KITTITAS VALLEY FIRE & RESCUE

March 28, 2008

I have reviewed the Application for the Sunset Farms Preliminary Plat (P-07-60). This proposed plat is located well over 5 miles from the nearest staffed fire station and is subject to extended fire and emergency medical service response times. This information is provided for information purposes for the developer / owner. During development, the following issues will need to be addressed:

**SITE PLAN  
OF  
SUNSET FARMS**

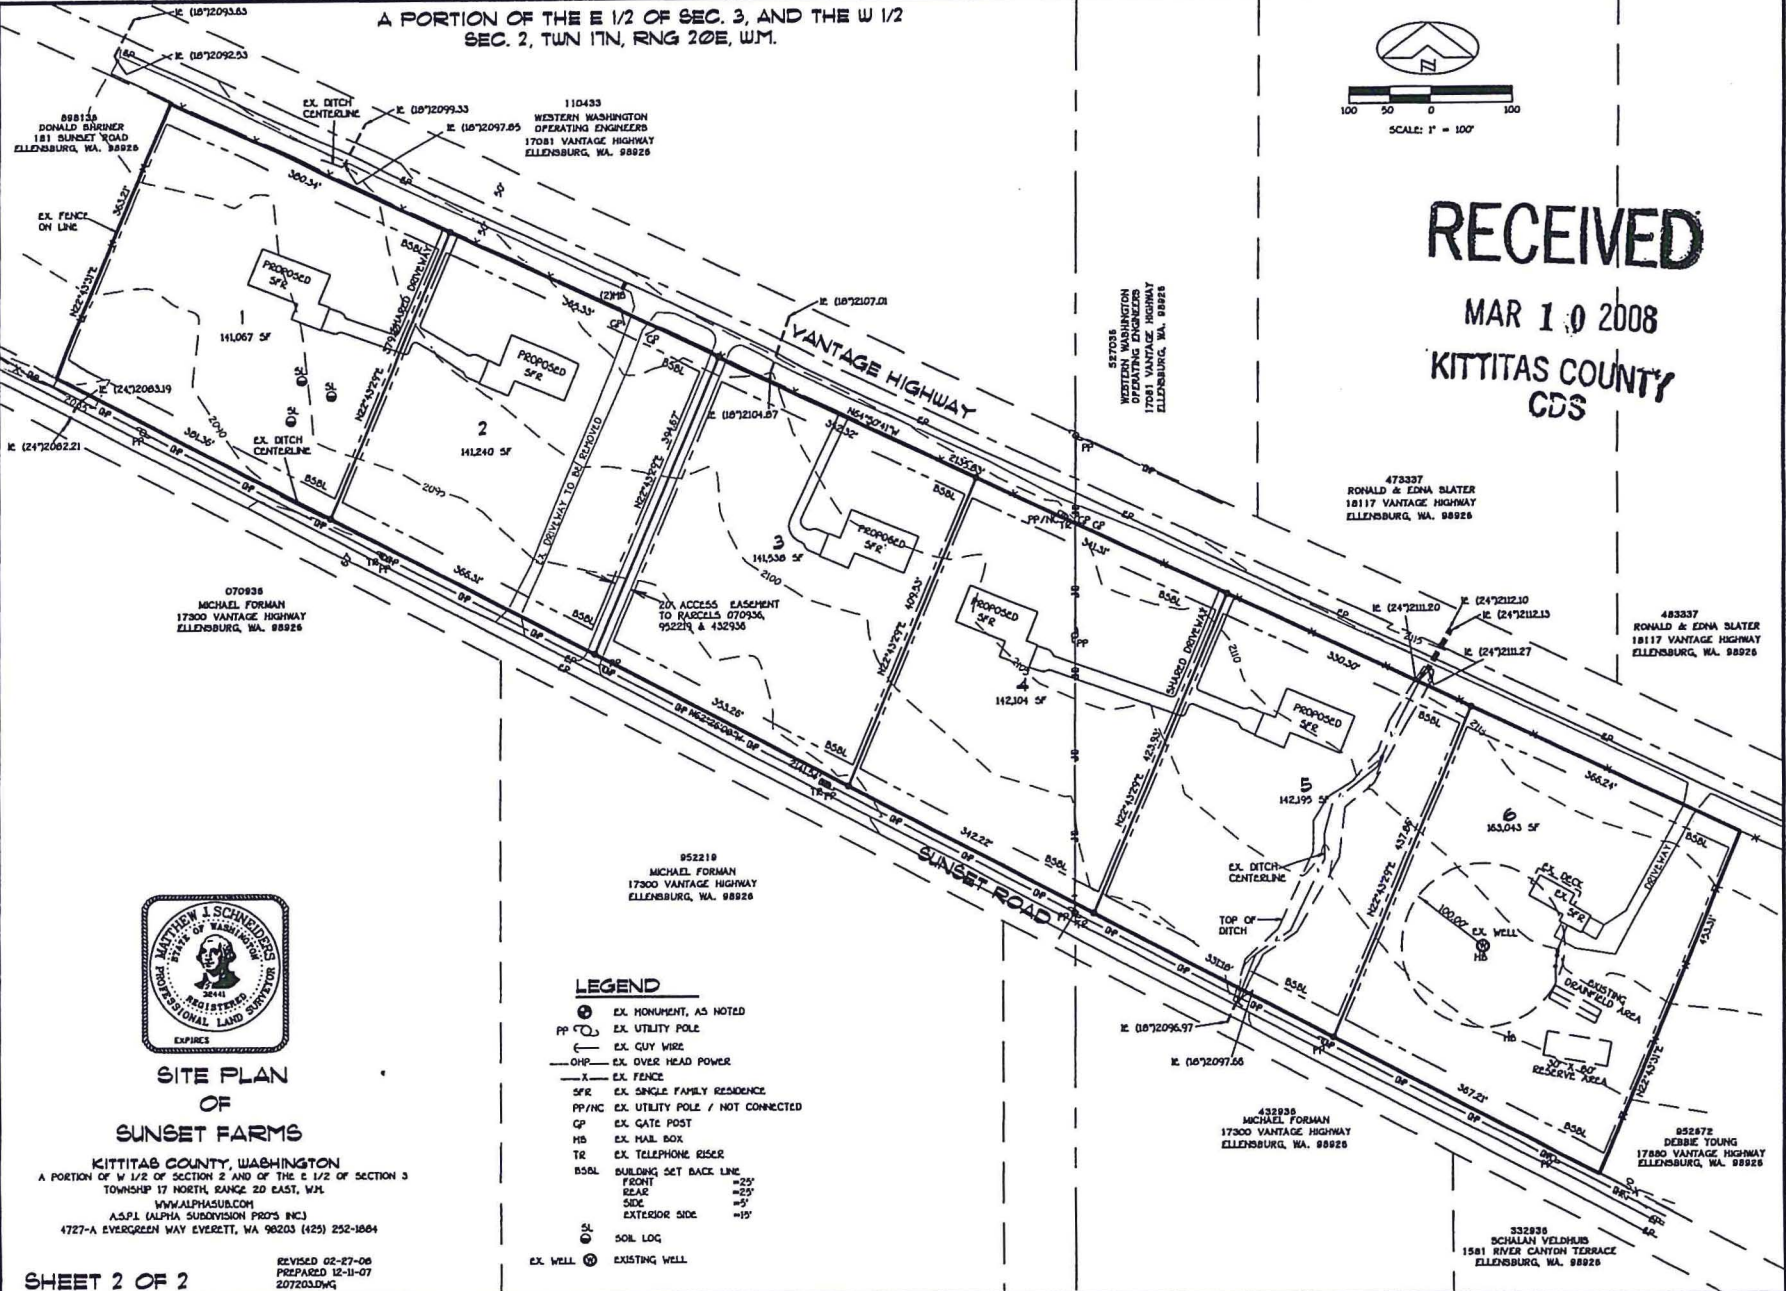
1. The addresses need to be clearly visible from both directions at the county road for all properties.
2. The fire department access road needs to be capable of supporting 75,000lbs in all weather, be 20' wide, provide 13'6" vertical clearance and provide for adequate turn-around for fire department apparatus in accordance with IFC 2006 – Appendix D if applicable.
